**Oakdale West Industrial Estate (SSD 7348 MOD 2)
Environmental Assessment Requirements (EARs)**

Oakdale West Industrial Estate, Kemps Creek, Penrith (SSD 7348) – Advice in relation to the Environmental Assessment Requirements for proposed Modification 2.

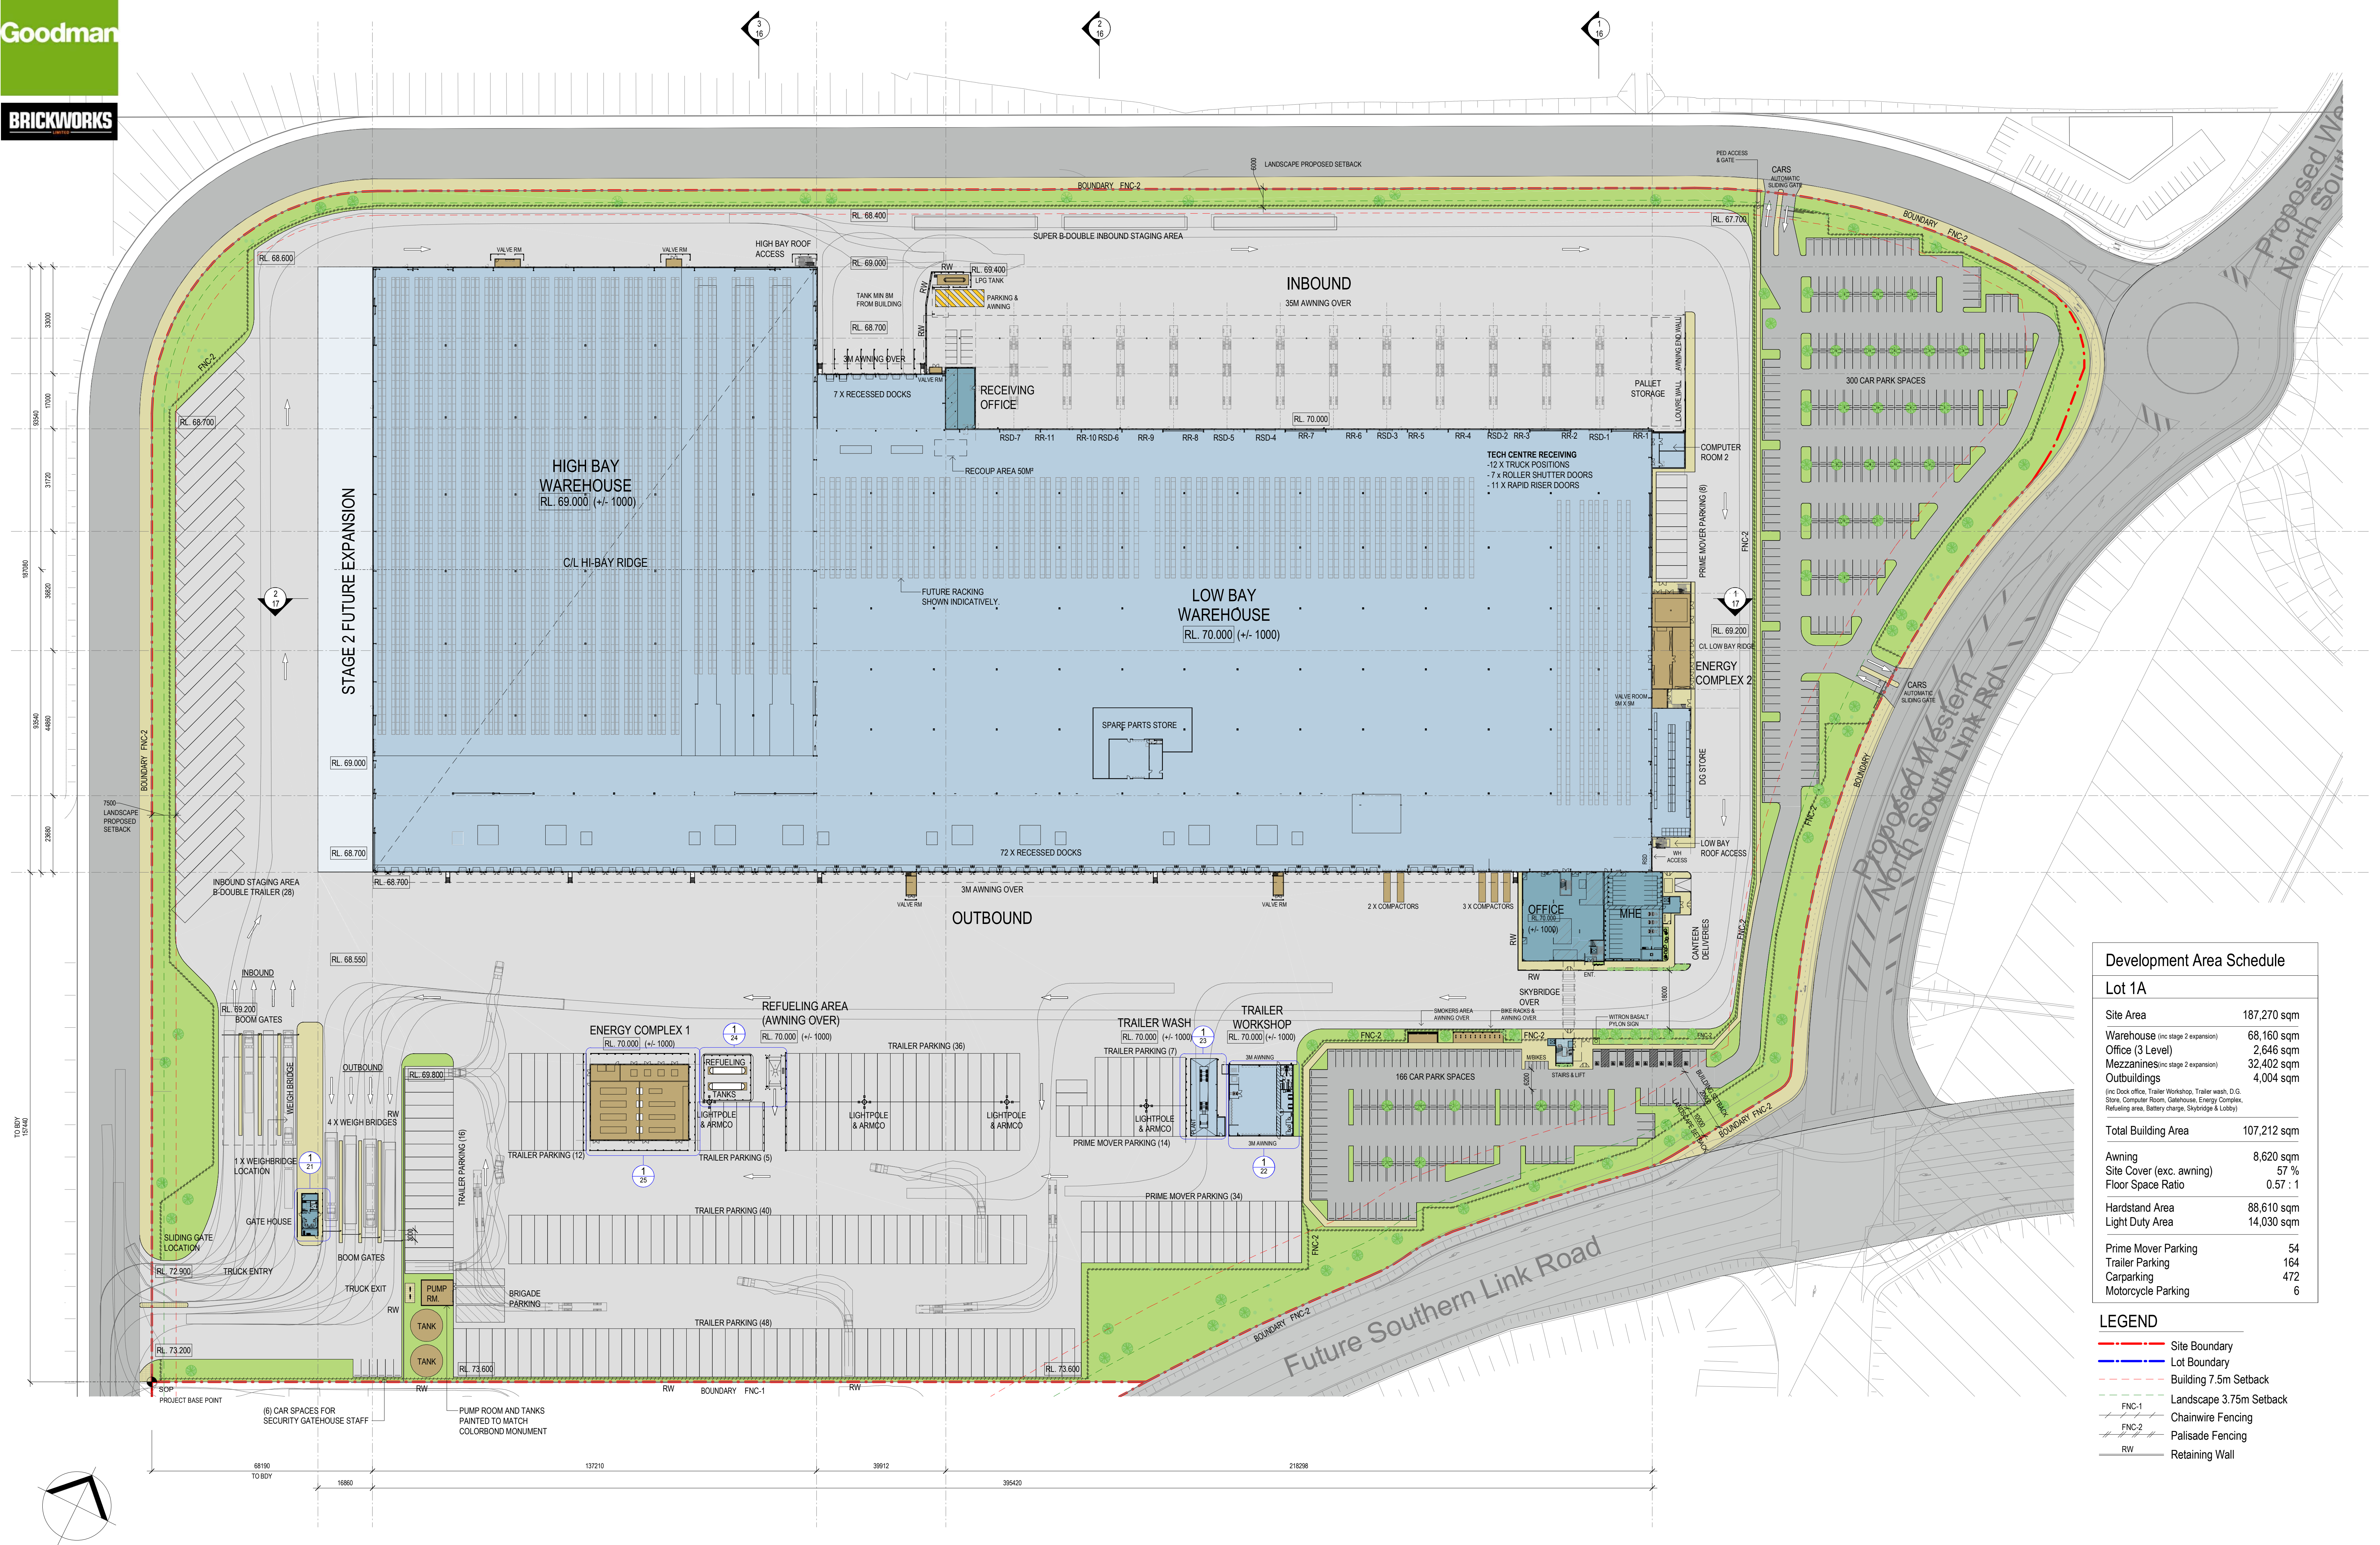
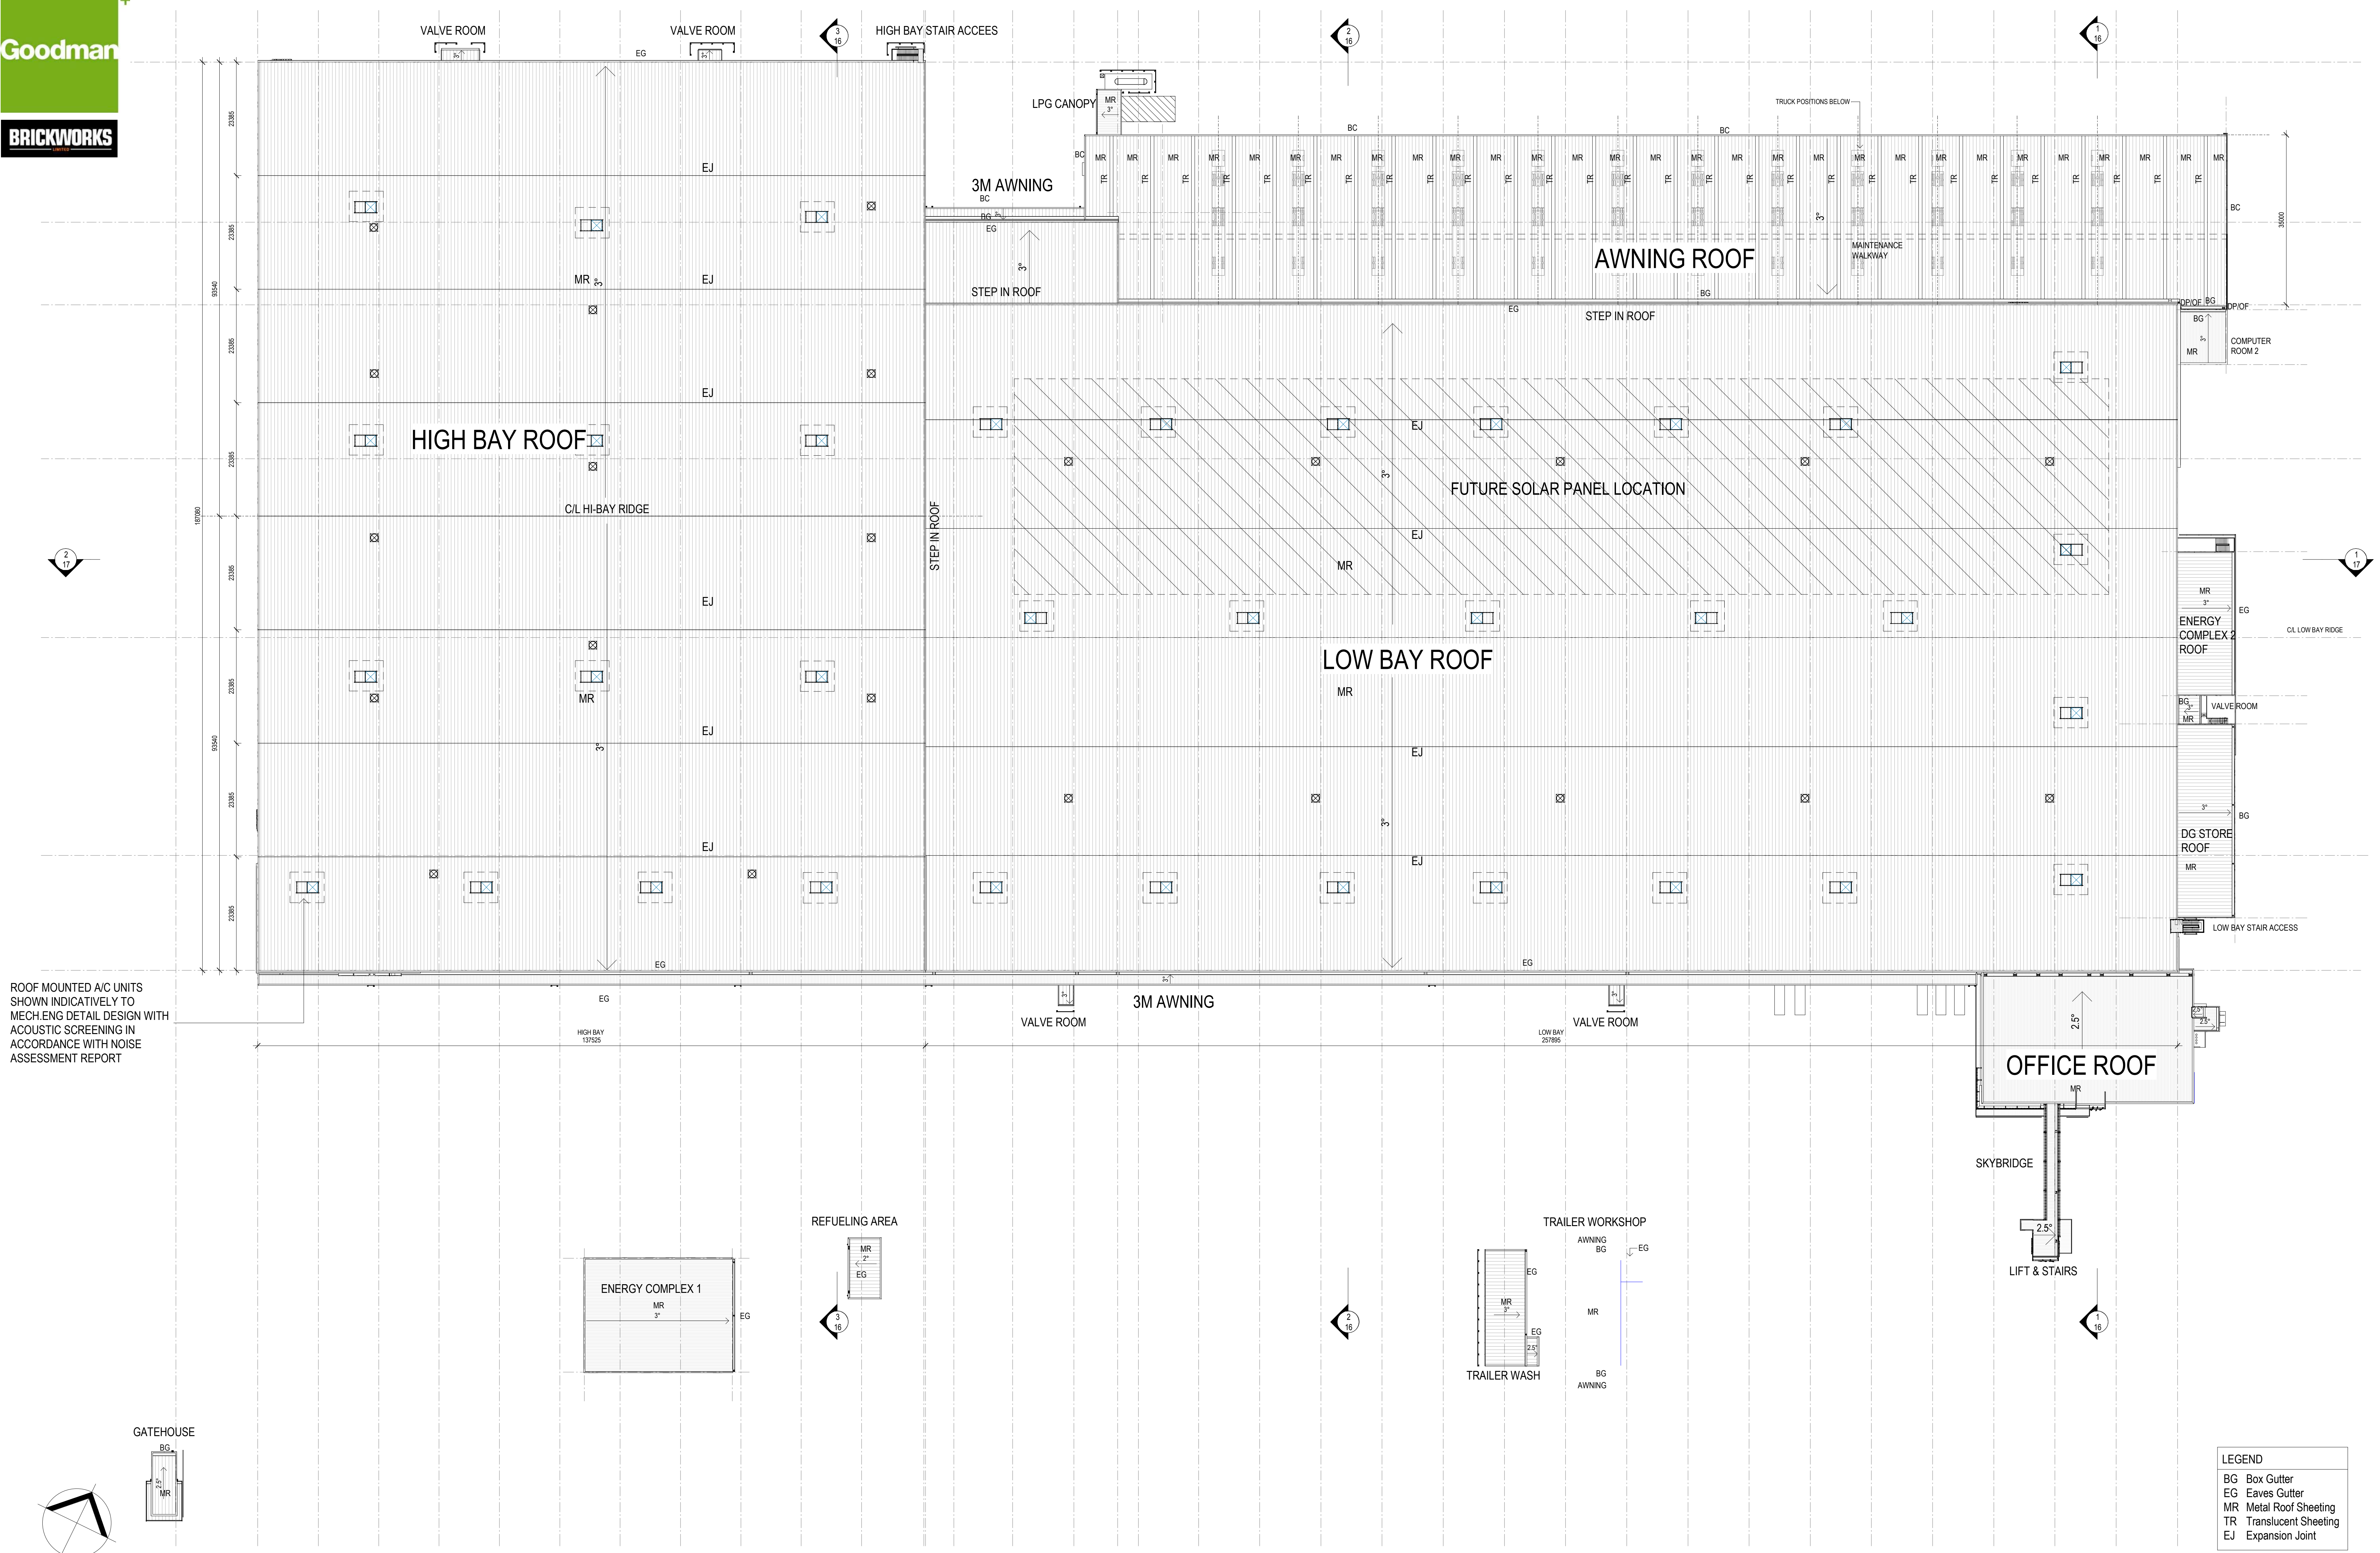
The amended subdivision arrangement and deletion of Estate Road 2 results in a reorientation of the building envelopes and an increased massing of built form to that previously approved. The approval as issued included 3 x buildings with separations that ameliorated the massing as viewed from Road 1 and the future southern link road. The approval also had significantly less parking protrusion in the road setback zones. The amended proposal however now provides for an elongated building (1A) with land subdivision south excising 1B and 1C. Lot 1A and the built form massing warrants a site area and landscaping capability that proportionately responds to the height variation sought and the reconfiguration of the proposed built form. The current arrangement provides for all staff and customer parking within the road setback zones which is not a suitable or supportable outcome having regard to streetscape presentation and necessary treatments to the link roads. It has been suggested to the applicant on 2 previous occasions that the size and scale of Proposed Lot 1A warrants deletion of Proposed Lots 1B and 1C with the proposed parking which is protruding into the setback zones relocated into this area. This would then enable embellished landscape setbacks that exceed minimum requirements in the DCP to be proportionately reflective of the extent of height variation sought. For example., if the parking from the gateway intersection of the north south link road and estate road 1 was relocated to the location of lots 1B & 1C, then the corner treatment to the intersection and round a bout would present a significantly improved and attractive arrival opportunity which would assist in ameliorating the massing and visual prominence of the elongated built form and would assist to support the proposed height noncompliance as viewed from the link roads. At present, the sites edge conditions, parking locations and resulting streetscape outcome is being adversely impacted by the expansion of the building length, building height and spatial arrangement of the indicated building envelope.
